WHAT BRICK WALL?

I write to object strongly to erection of monopole 5G mast in application 23/00750/TEL56

Title: **100 EXISTING SITE PLAN**

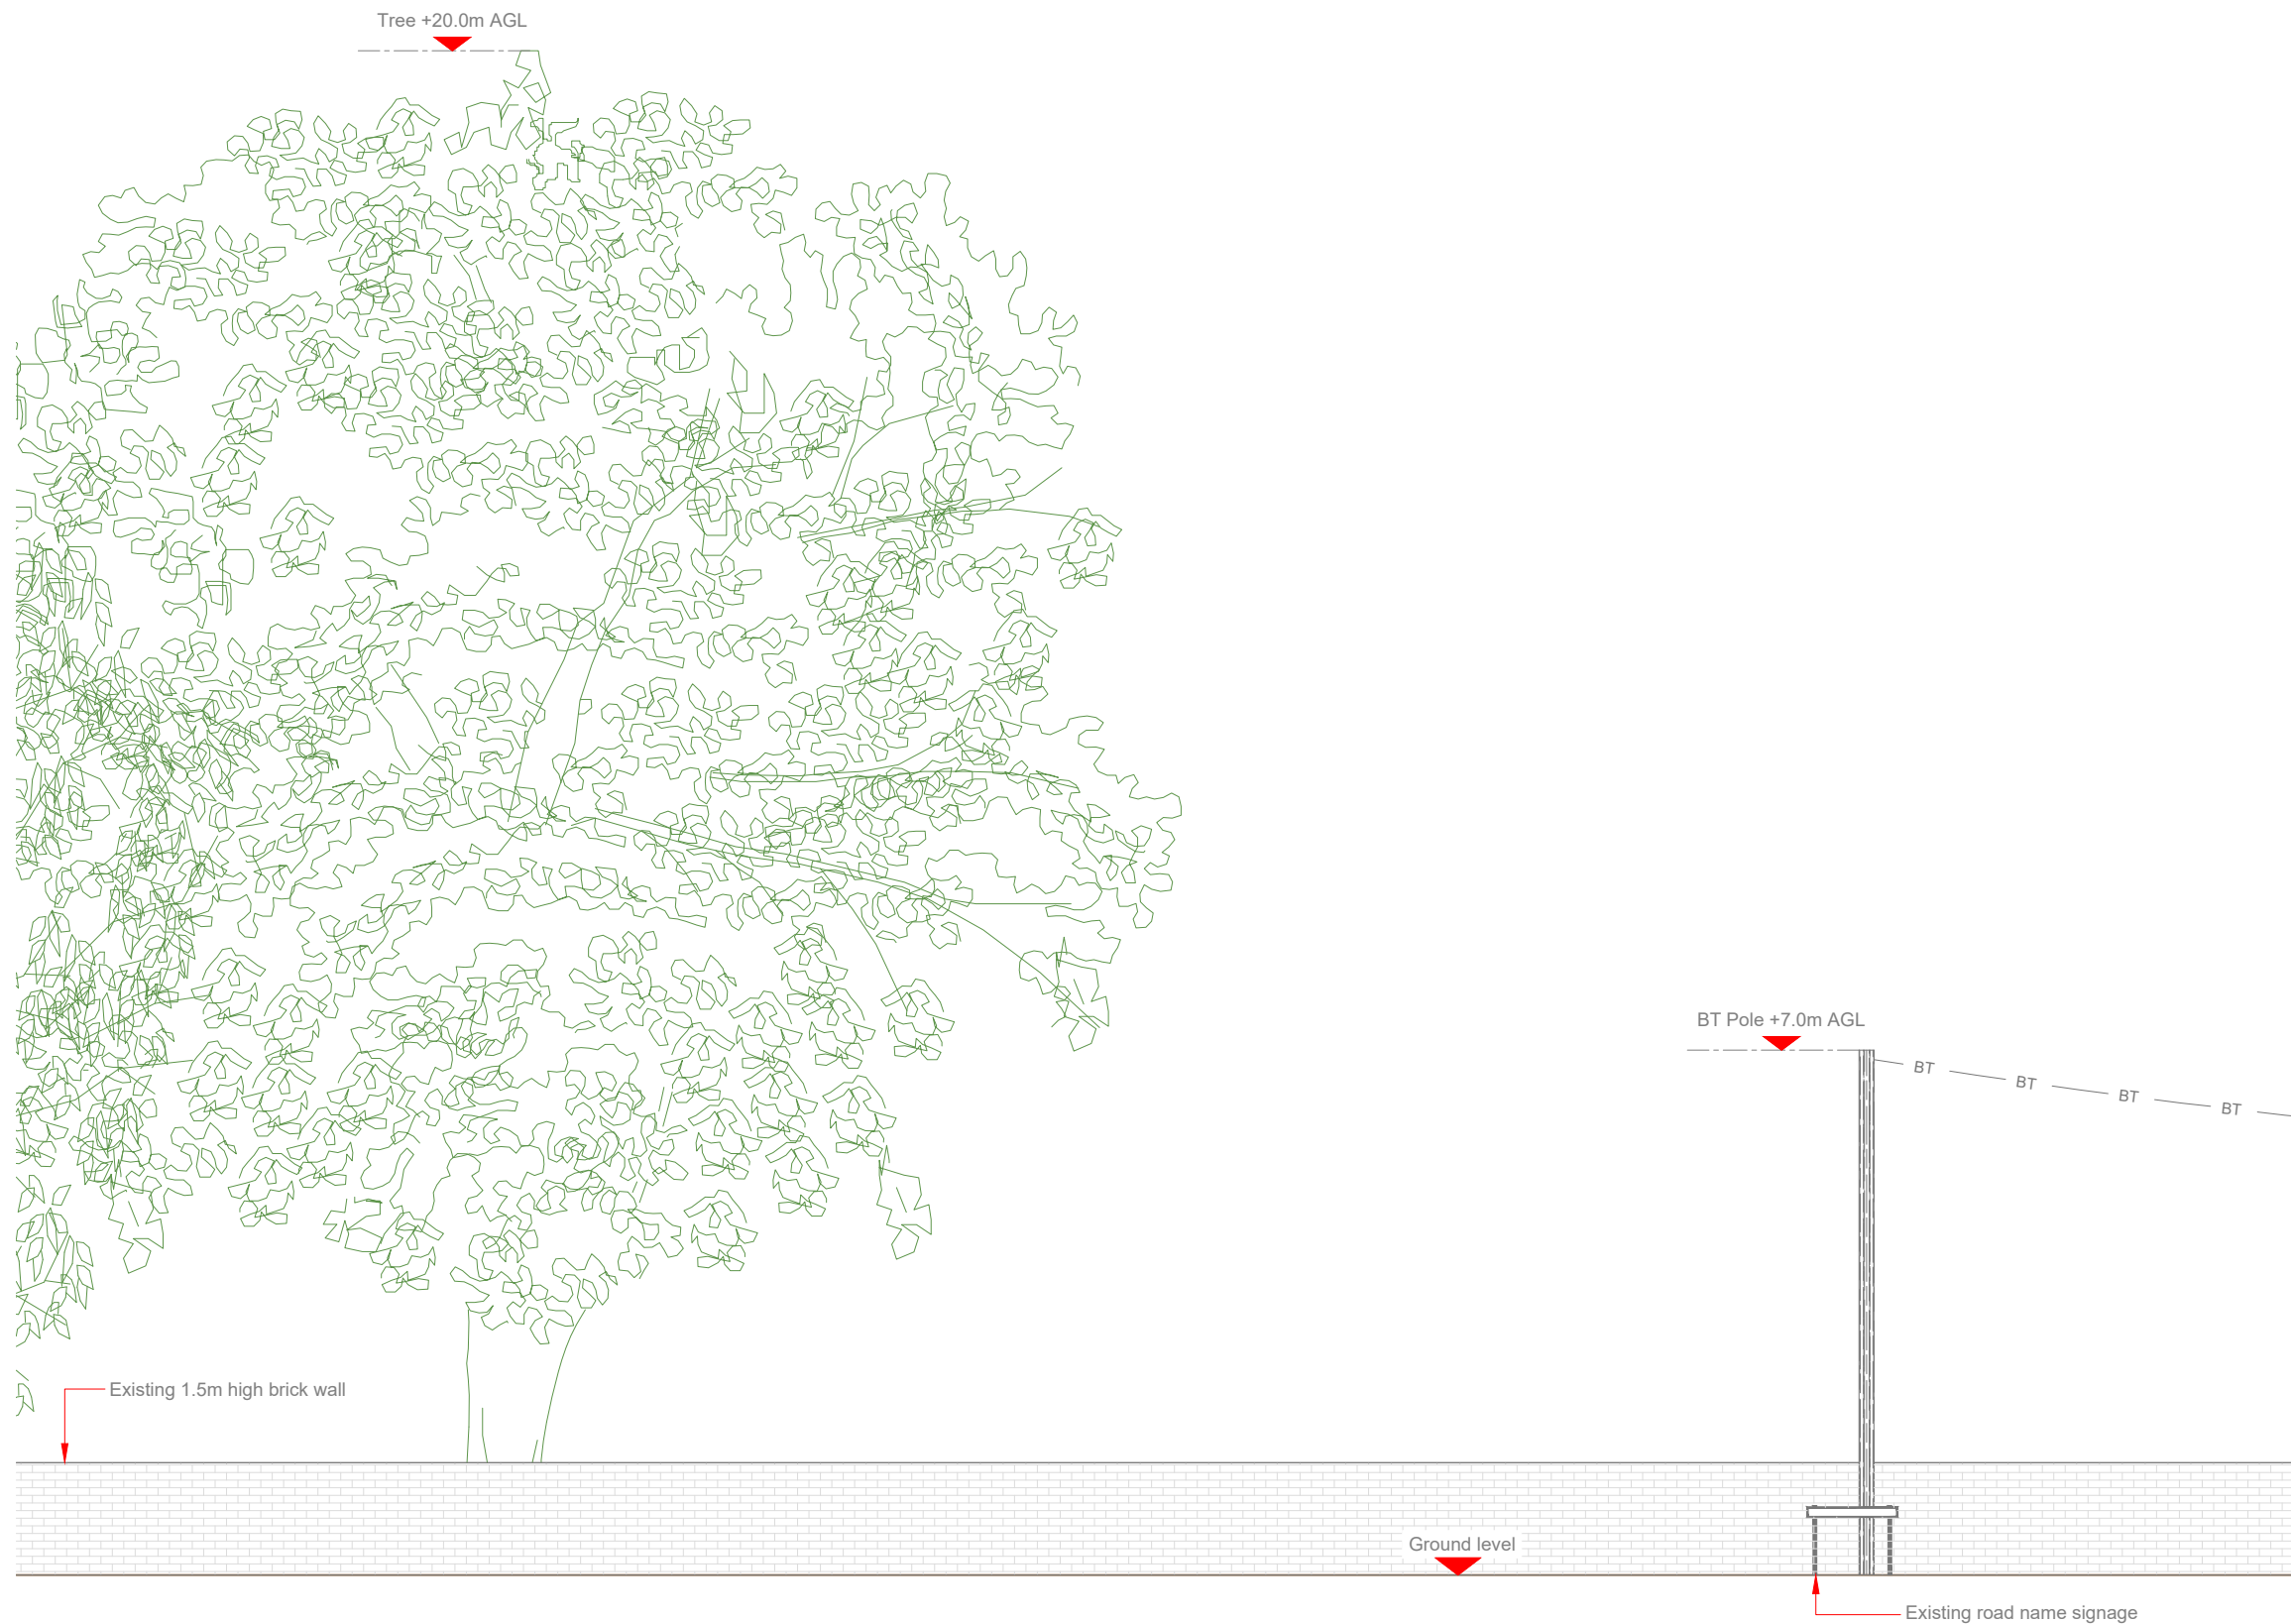
To the due South of the site the land drops away to fields and then up again to Bletchington. From this direction the mast will be seen from a distance. There are several errors in what the application suggests is there already. Figure 4 shows a portion of the traditional limestone (not brick!!) wall.

Fig.4: Looking due South, a short section of the limestone wall, referred to as a brick wall in the application. It is also not a very high wall.

Furthermore, there is no street lighting here.
